From: Amanda Scholes on behalf of Planning.Responses
Sent: 23 May 2019 09:00
To: Planning Scanning
Subject: FW: A/175/18/PL - Caffyns Temporary Car Park Extension - Drainage

Figure 4: Proposed site layout for temporary car park extension

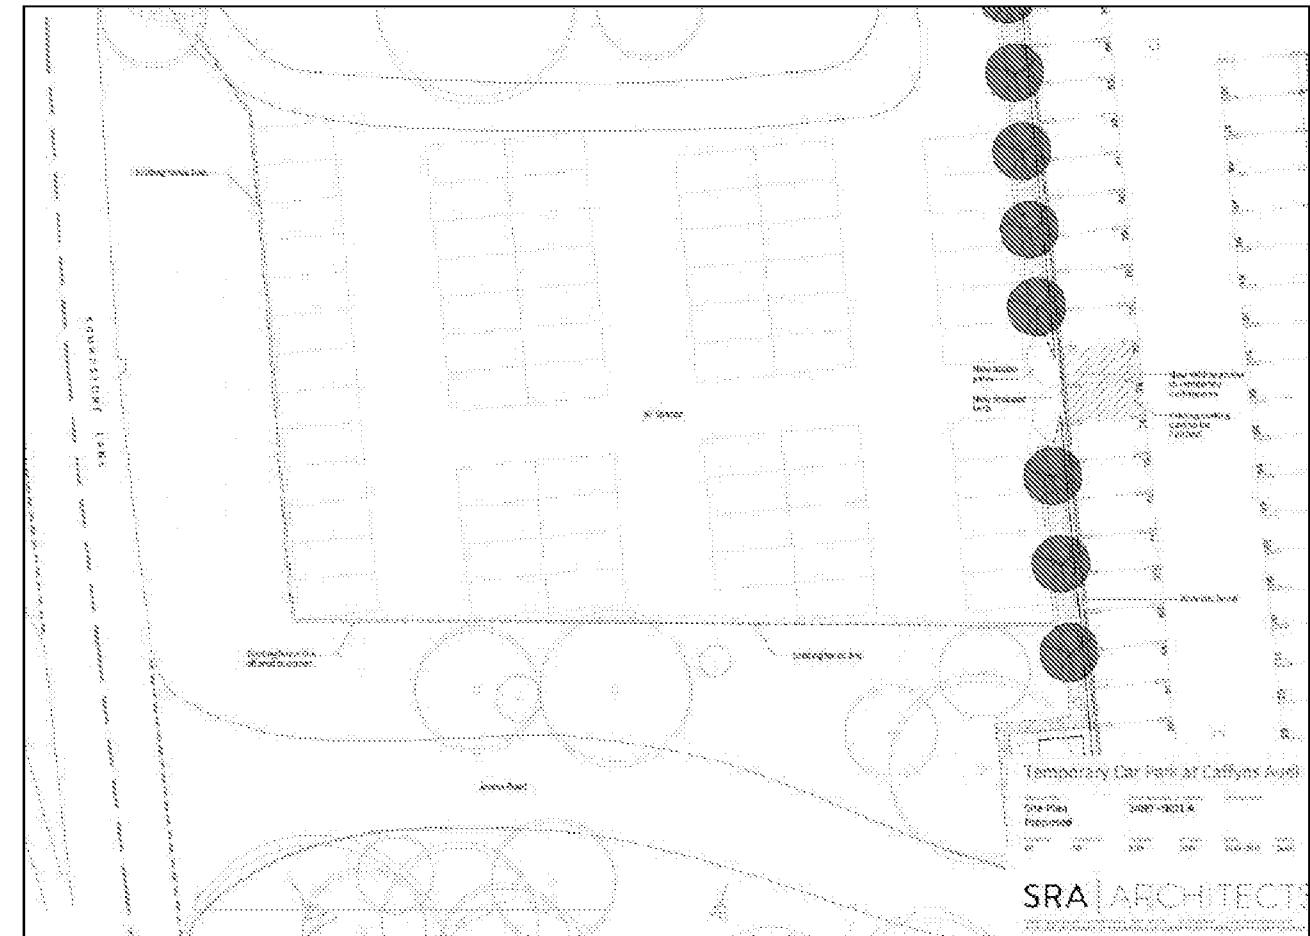
It also worth noting that the proposals are to form a permeable car park area. However, 6F2 material is being specified, this class of material can include fines and therefore is not suitable. We therefore request that the plans are amended to show 300mm type 3 stone sub base.

It also worth noting that the proposals are to form a permeable car park area. However, 6F2 material is being specified, this class of material can include fines and therefore is not suitable. We therefore request that the plans are amended to show 300mm type 3 stone sub base.

Please find attached the amended Drainage report which seeks to address the concerns raised by the LLFA. We have completed a topographical survey and demonstrate that the proposed permeable surface material will be generally level but will include a gradient from the perimeter to the centre such as to discourage run-off from leaving the area but instead infiltrating via the permeable medium proposed. The specification of the permeable surface is 150 mm of 6F2 material with a permeable geotextile and then 150 mm of type 3 stone. The existing drainage arrangements will therefore be replicated and enhanced through the removal of existing concrete paths within the area, increasing the ability of the sub-soils to receive and retain rainfall.
